24 April 2013

NSW Department of Planning & Infrastructure  
Major Projects Assessment  
23-33 Bridge Street  
SYDNEY NSW 2000

**Staged Development Proposal - Pymble Ladies College (SSD5314)**

PROJECT PLC Aquatic Centre		PROJECT # 2126
CLIENT Pymble Ladies College		DWG # A102
DWG Parking numbers- Proposed		REVISION A
CLIENT REF & CONTACT Avon Rd, Pymble NSW 2071	DATE 20/08/12	DRAWN CHKD

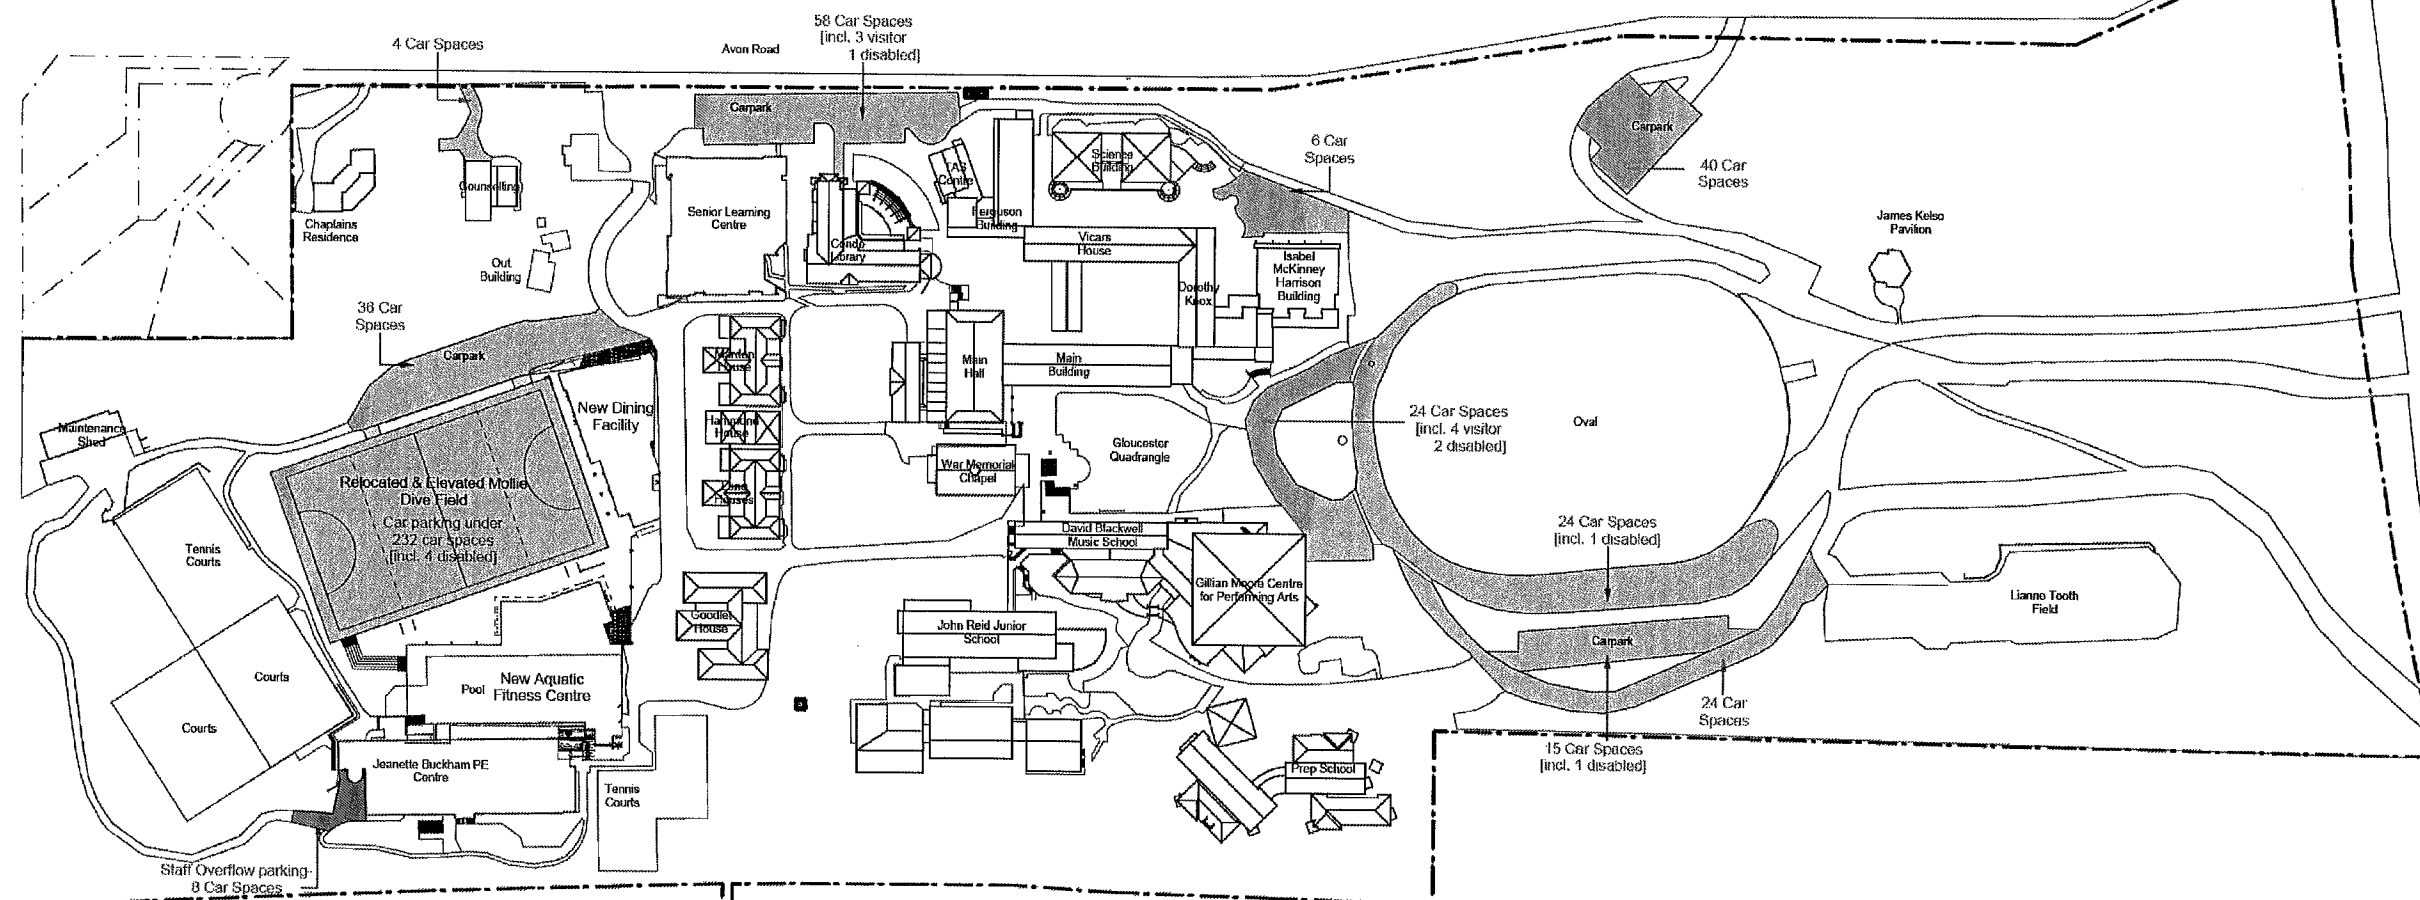
Both the Department and Council have expressed a concern about the 'excess provision of 135 spaces above the Ku-ring-gai DCP requirement', and seeks 'further justification for the proposed excess car parking provisions and clarification for the intended use of the excess spaces'.

- On-site parking is provided for a total of 275 vehicles within a number of parking areas within the College campus, including staff parking areas and on-site parking adjacent to the upper and lower access roads;

- The proposed works, including the new car park beneath the sports field, will provide a total of 470 car parking spaces. However, in order to improve safety for students and to provide emergency vehicle access during the morning and afternoon peak periods, 25 of these spaces (located around the ring road) will not be available during the morning drop off and afternoon pick up periods. This results in 445 spaces available at peak times.

- Based on an existing parking demand of 360 vehicles and an expected increase in the learn to swim parking demand of some 25 vehicles, as set out in the Traffic Report, the expected parking demand would be some 385 vehicles.
